ARCHITECTURAL DESIGN STATEMENT ADDENDUM

Prepared in response to DPHI request for further information dated 16 February 2026.

16-24 LORD STREET & ROSEVILLE 21-27 ROSEVILLE AVENUE

MARCH 2026

F SECTION F
 SCALE 1 : 100

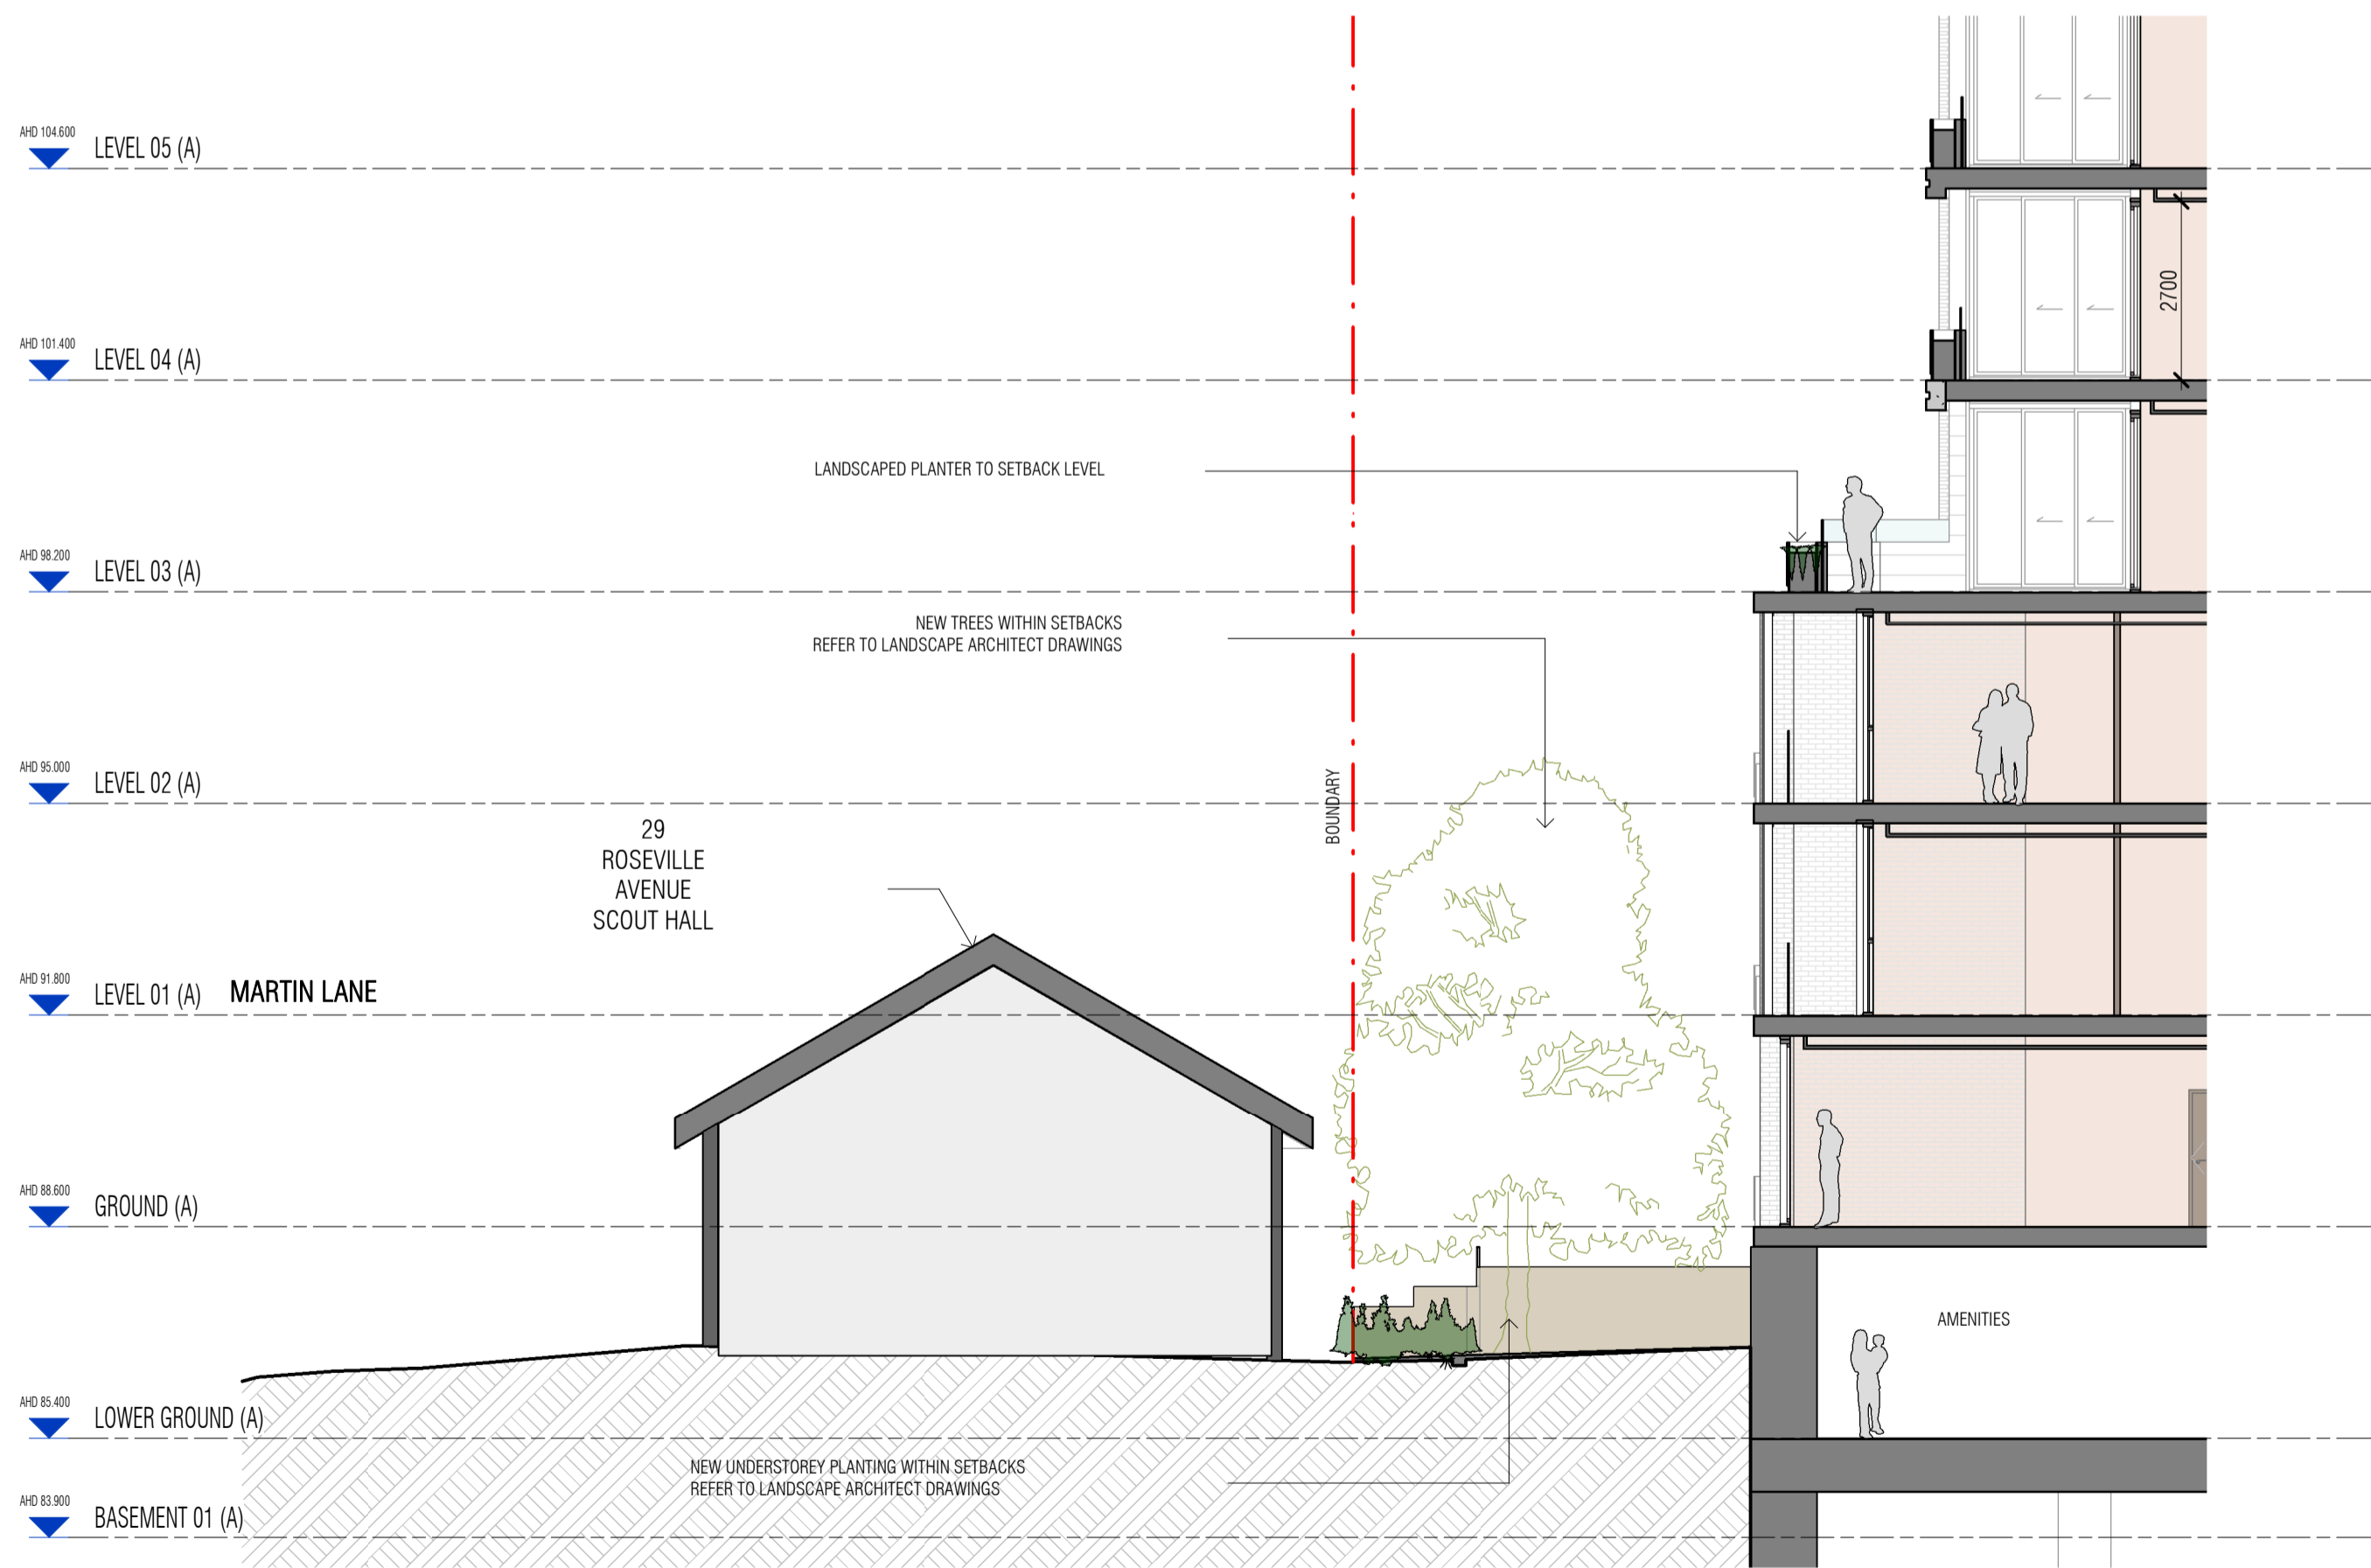
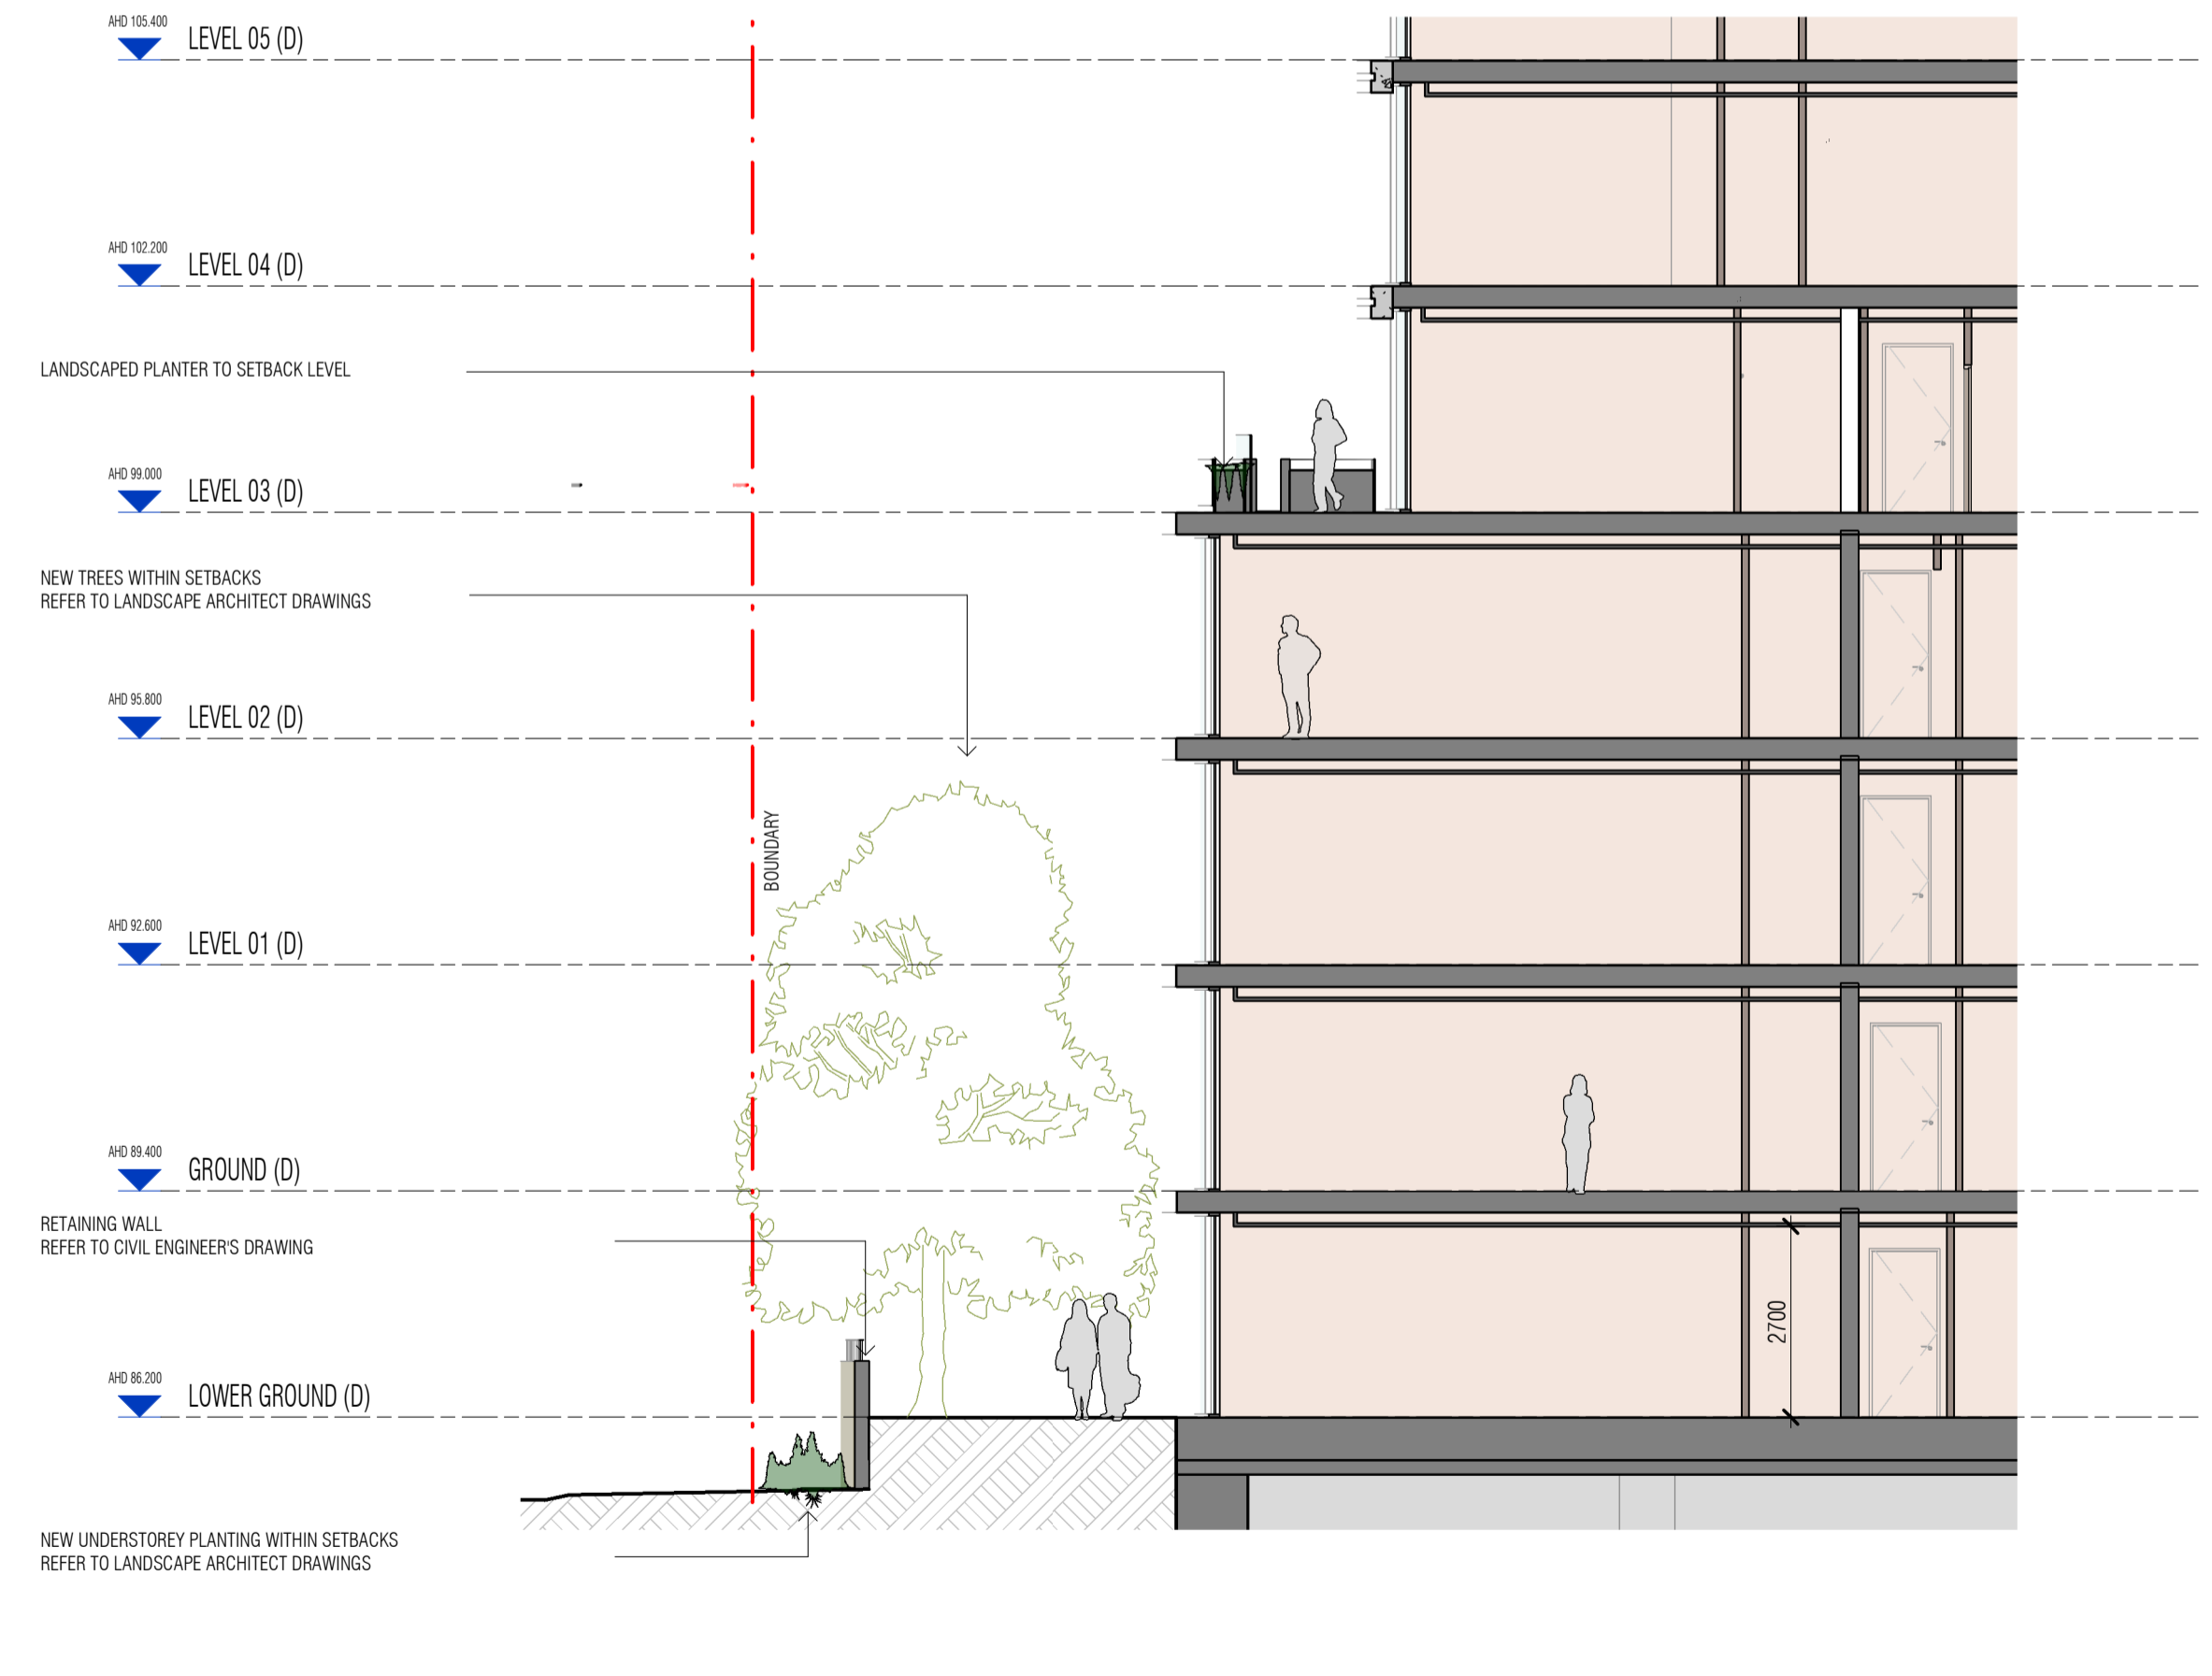
1.1 The proposed heights of the podiums should reflect the existing topography and provide a transition in scale to the adjoining context, particularly the Scout Hall. The Department recommends that you reduce and step the podium heights of Building A and D to further improve the relationship with the streetscape.

The design has been refined to allow for a further reduction in the eastern portion of Building A from 4 to 3 storeys to create a stepped podium form that follows the sloping topography of Roseville Avenue while reducing the visual bulk of the building when viewed adjacent to the lower scale Scout Hall building adjacent.

The eastern end of Building D has similarly been reduced from 5 to 4 storeys to accentuate the stepped form of the Lord Street elevation.
